## **Bernalillo County Regional Recreation Complex Mesa del Sol, draft TIS**

HT# R15D002

COA preliminary observations and comments 5/11/2022

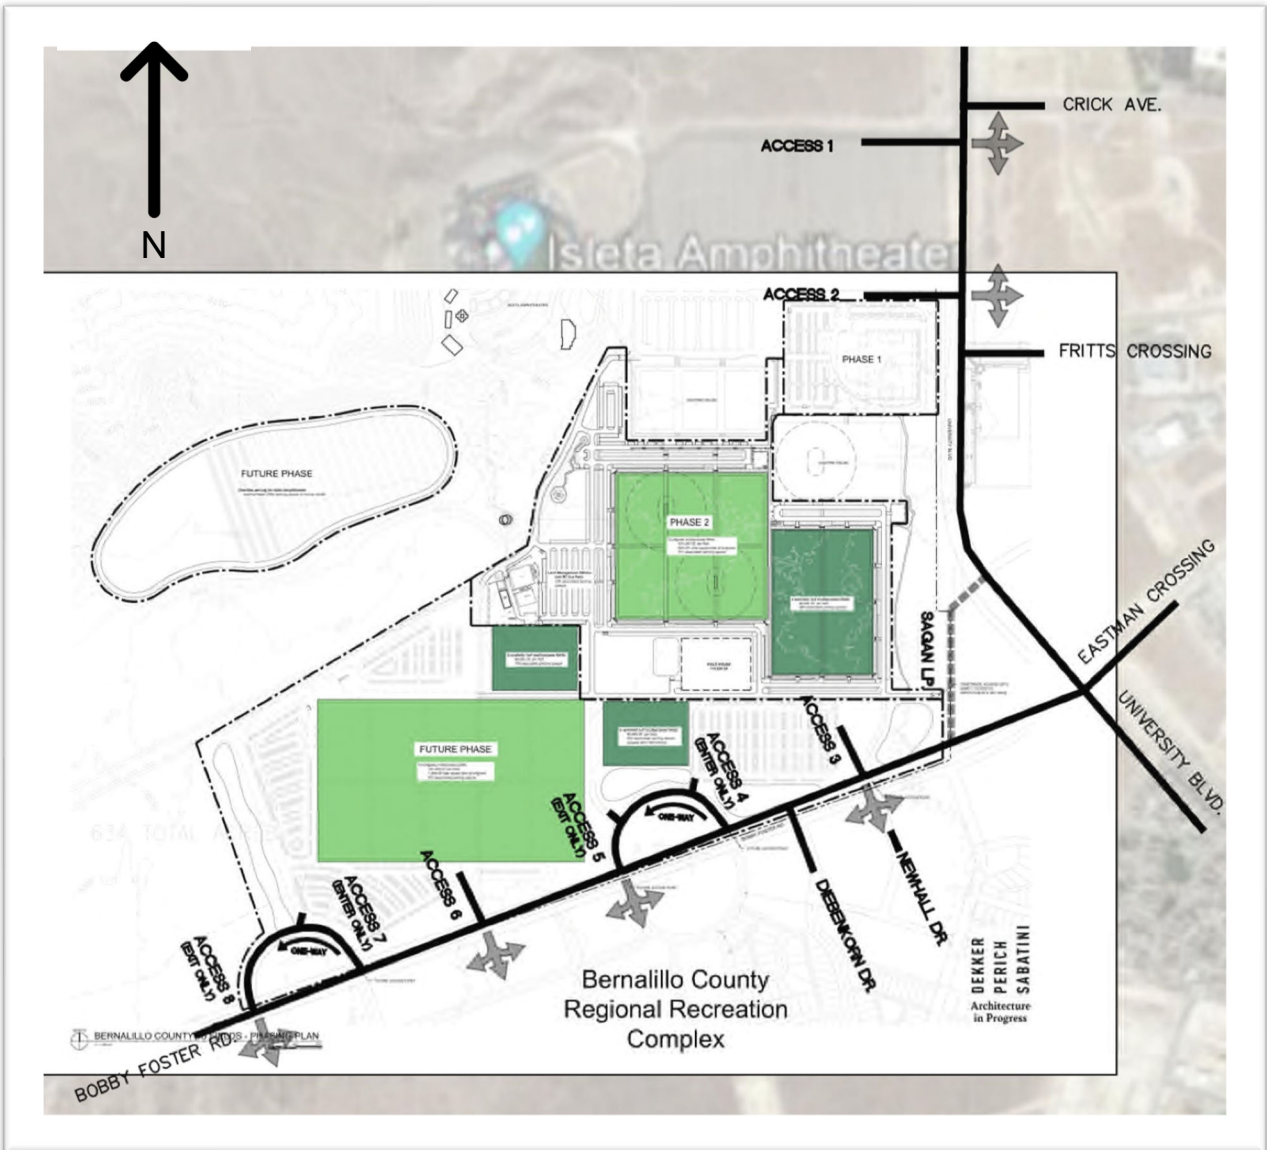
The mis-alignment of Fritts Crossing with the Access #2 should be addressed as the traffic not being associated. The two streets do not serve the same traffic, east of University is commercial large businesses and the west side is a recreation complex. The separation is approximately 300 feet and could function independently. This should be investigated in the report. ABQ Studios are vacating the streets connecting to Fritts crossing. This will restrict growth associated with Fritts Crossing. Additionally, access to Frits Crossing can be from Crick Ave. using Turning Drive and Watson drive. The misalignment of Crick and Fritts has been addressed in the TIS. We agree that misaligned access points can be problematic, however, volume of the side street traffic is a factor in this determination. With current side street volumes and the introduction of a continuous two-way-left-turn center lane we do not anticipate unacceptable crash rates due to overlapping turns. This is supported by an article provided in the Appendix of the TIS. See article from the NRC Research Press, "Investigation of the Performance of Two-Way Left-Turn Lane on Roads with Staggered Intersections," in Appendix pages A-236 thru A-249. If crash rates do increase as volumes increase, we have recommended limiting access at Access 1 to right-in/right-out/left-in only until Access 1 can be aligned with Crick Ave. Because the traffic volumes at Fritts Ave. are low and expected to decrease when ABQ studios vacate connections and is 260-ft from Access 2, no recommendation have been made to correct the misalignment.

Crick Ave. and Access #1 should be aligned. They are too close together to operate independently and the traffic volumes on Crick Ave. will be increasing due to development potential east of University.
